Application No: AL/67/20/HH  
Site Address: Lulworth Fontwell Avenue Eastergate PO20 3RU  
Description of works: 1st floor side elevation, conversion of garage to habitable use and change of window in dormer to create balcony. Two storey detached garage with accommodation to rear

Thank you for your internet representation made on 11th October 2020 which has been recorded as an objection with the comments as follows:

SITE PLAN 1:500 @ A4

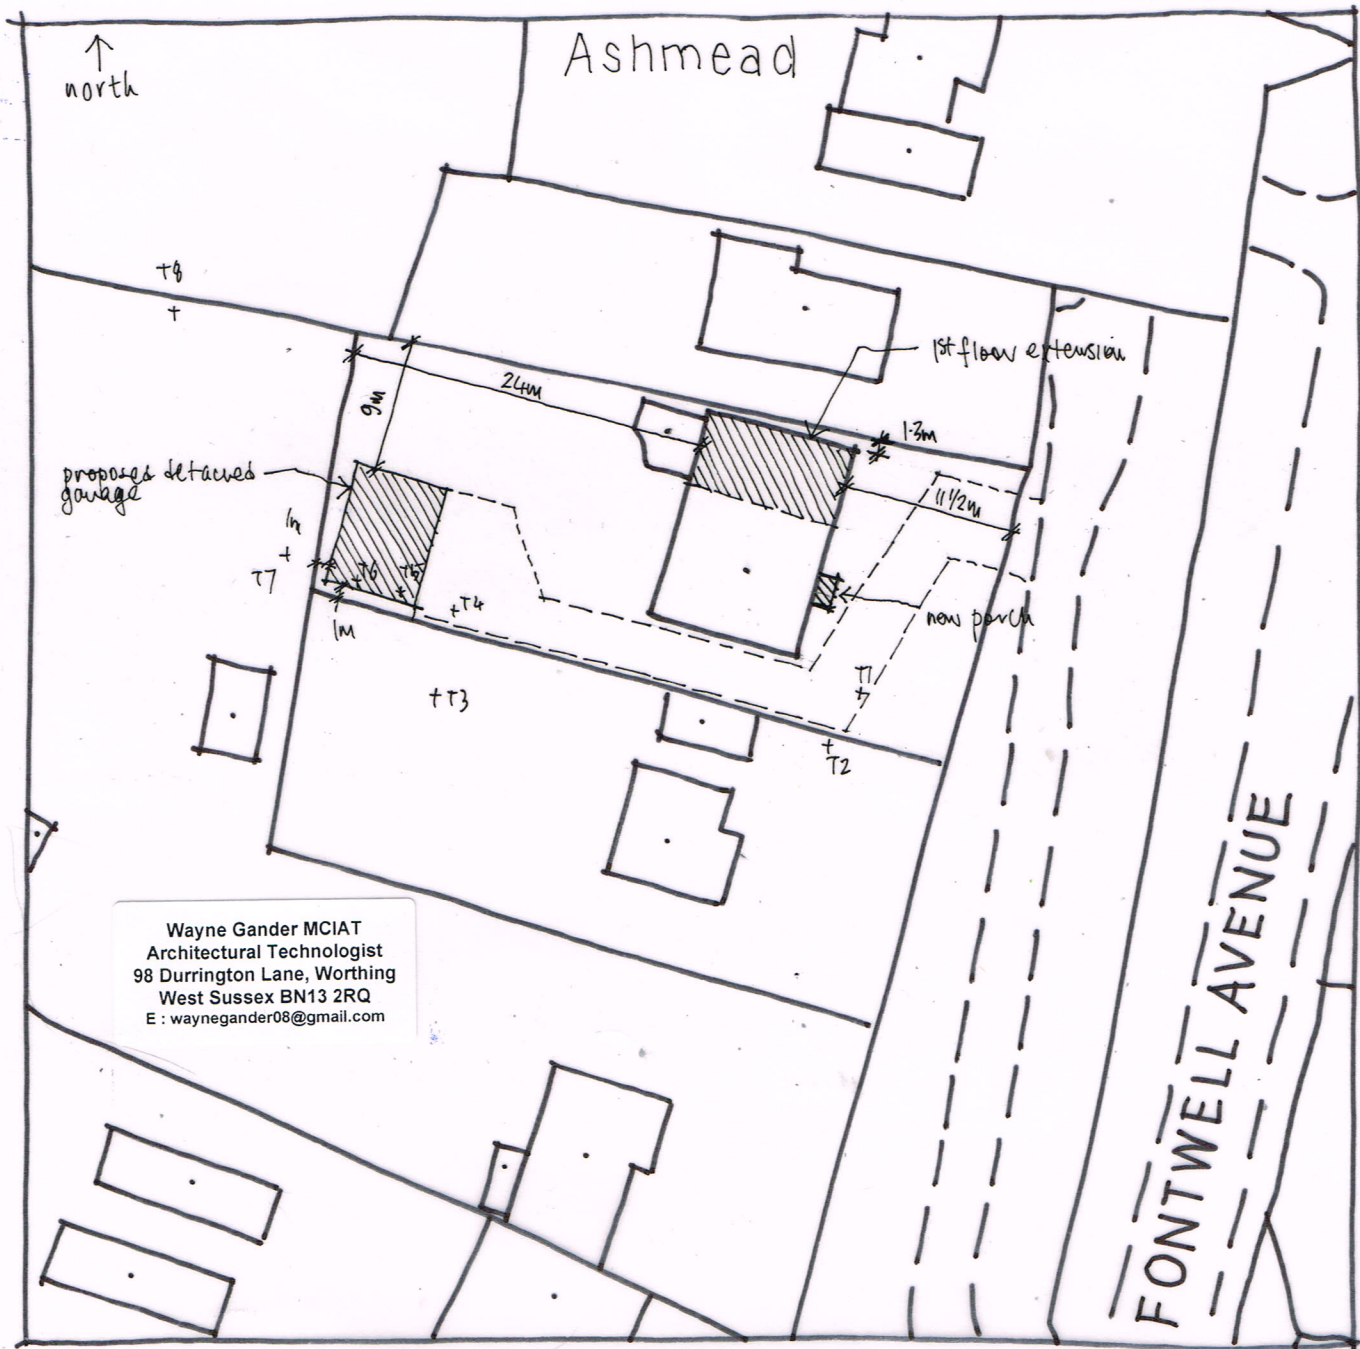
rear garden and activity of adjoining property "Fairways" as well as unrestricted views into the rear bedrooms and bathroom windows of "Fairways". The ground level on which the garage is to be sited is at least one metre above the ground floor level of "Fairways" increasing the loss of privacy. The lights from the "accommodation" above the garage will illuminate the rear garden of "Fairways". The mature/ established trees in the rear garden of Lulworth will be removed to make way for the garage driveway.

Three vehicles accessing the garage day or night will create a noise and light pollution disturbance as the drive is immediately along the "Fairways / Lulworth" boundary.

1st FLOOR PLAN

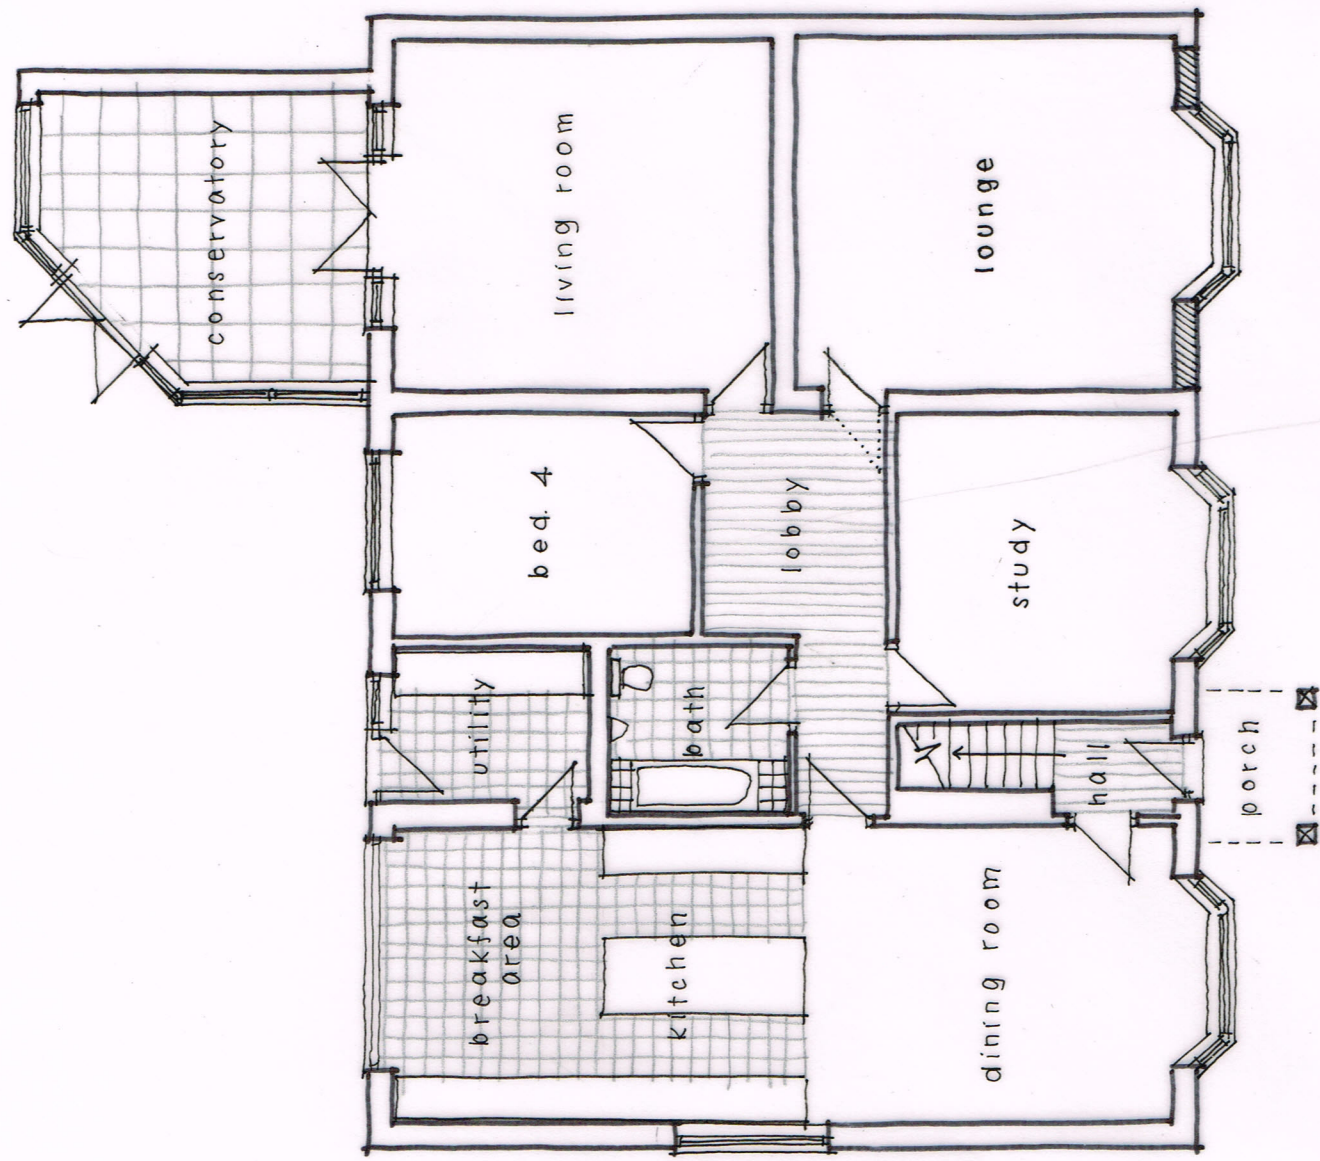
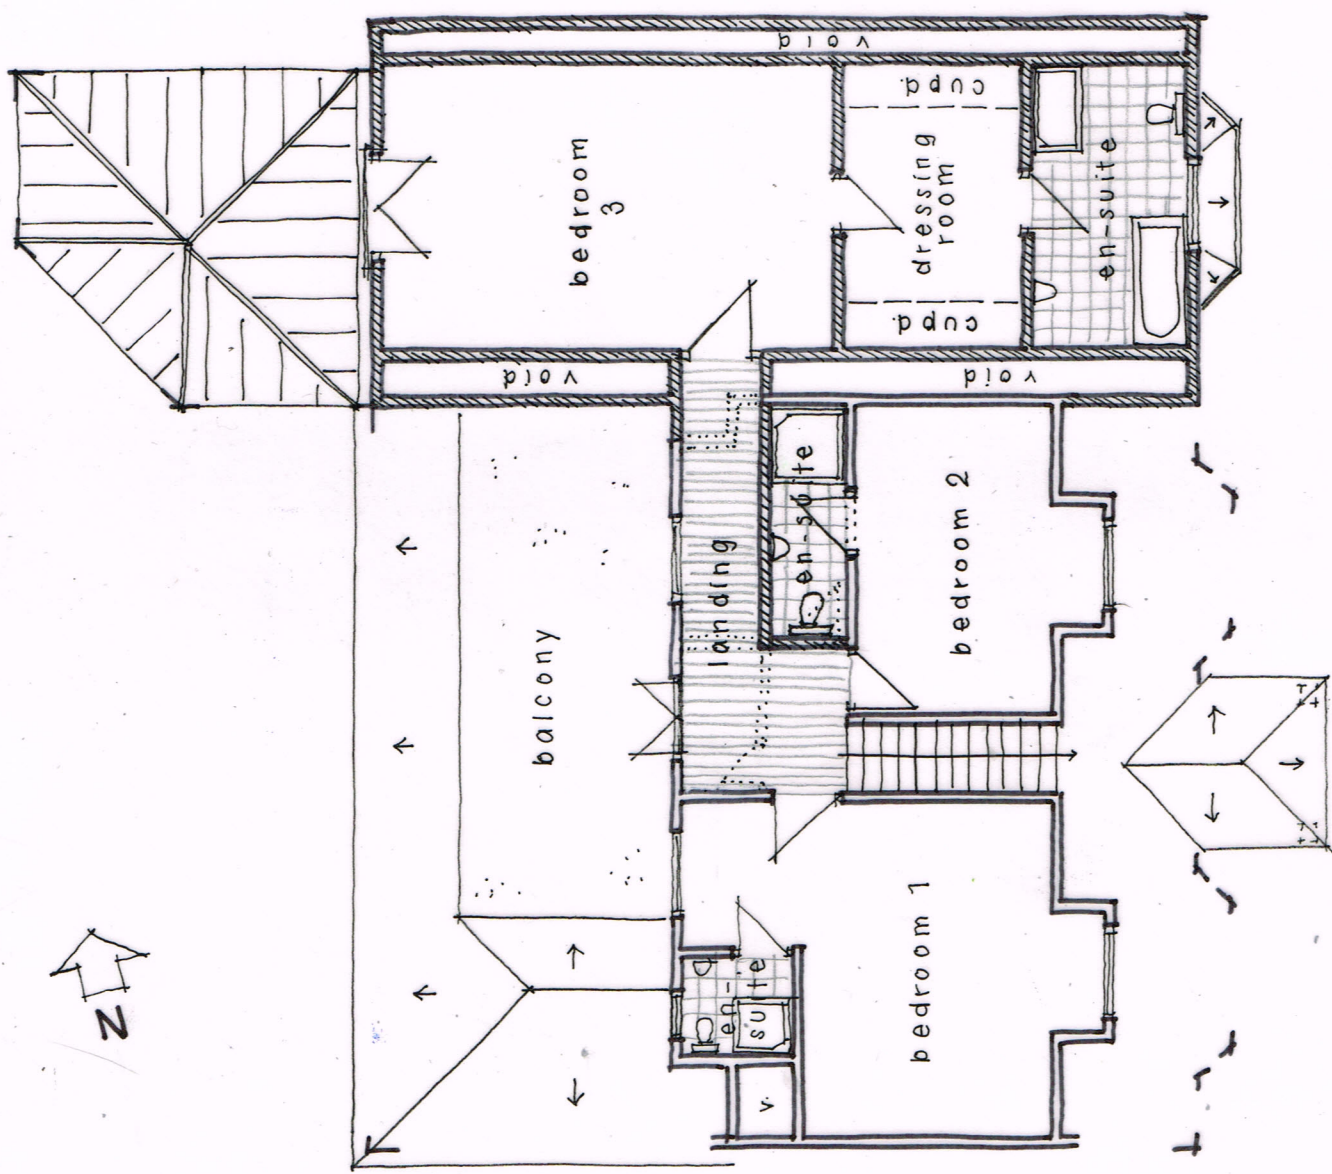
The new first floor balcony area will give a clear view over the adjoining properties of Fairways, Westfield and Rowley rear garden from a first story height removing any Privacy of Use or Activity.

FRONT (e) ELEVATION 1:100 @ A3

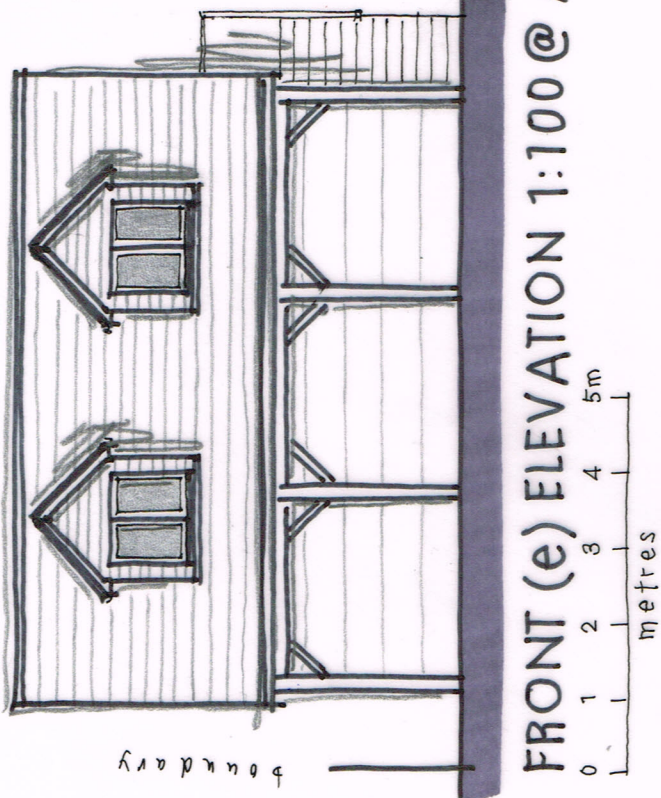
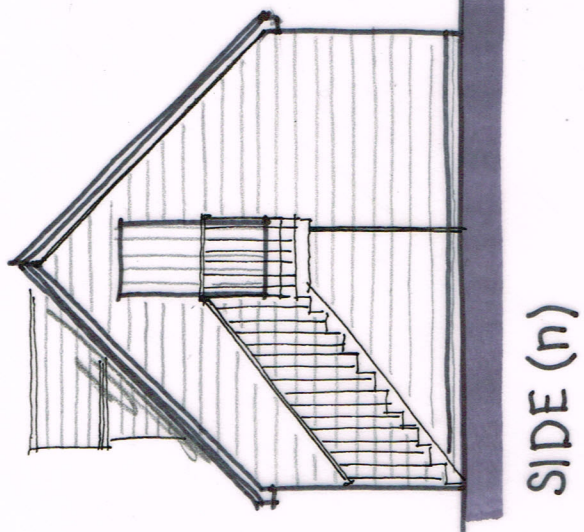
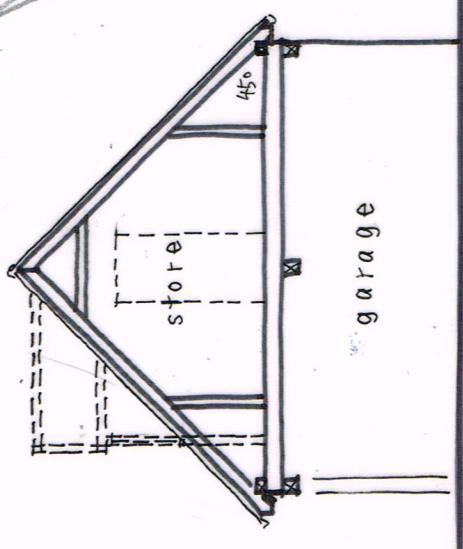
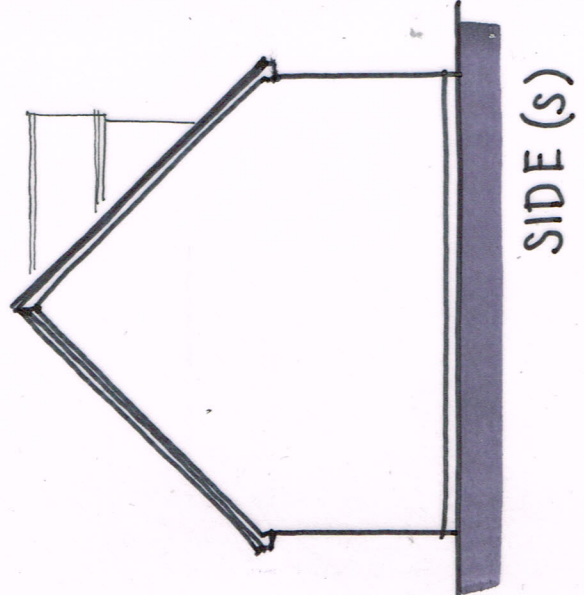
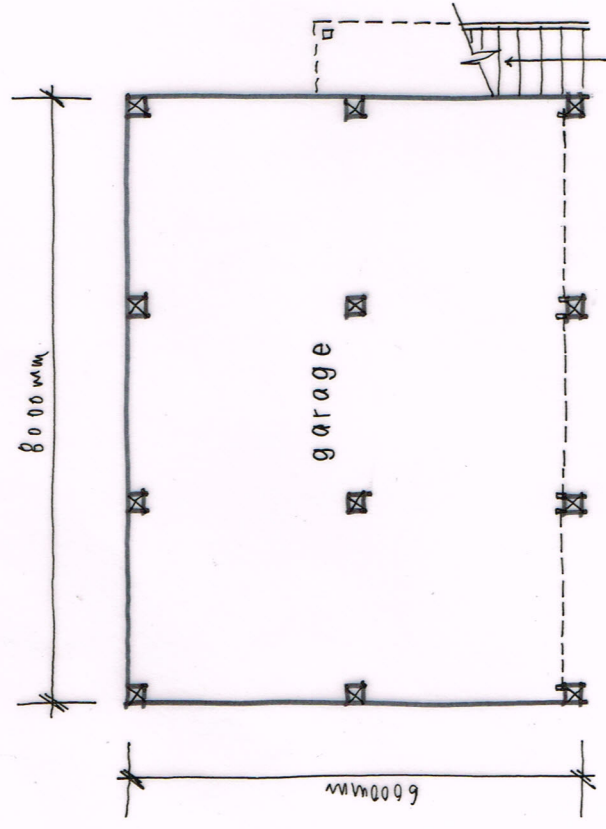
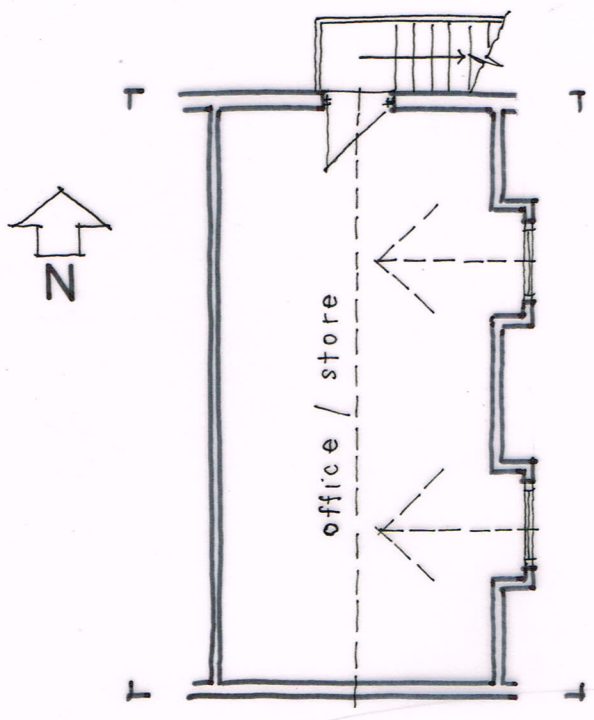
The detached triple two storey garage with "accommodation" on the first floor will give a clear view over the

The "accommodation" to the garage first floor will increase the ridge height of the structure and be intrusive in appearance from the rear garden of adjoining property "Fairways". A two storey garage structure increases the likelihood of creating a separate Dwelling in the future and will set precedence for neighbouring properties in the area.
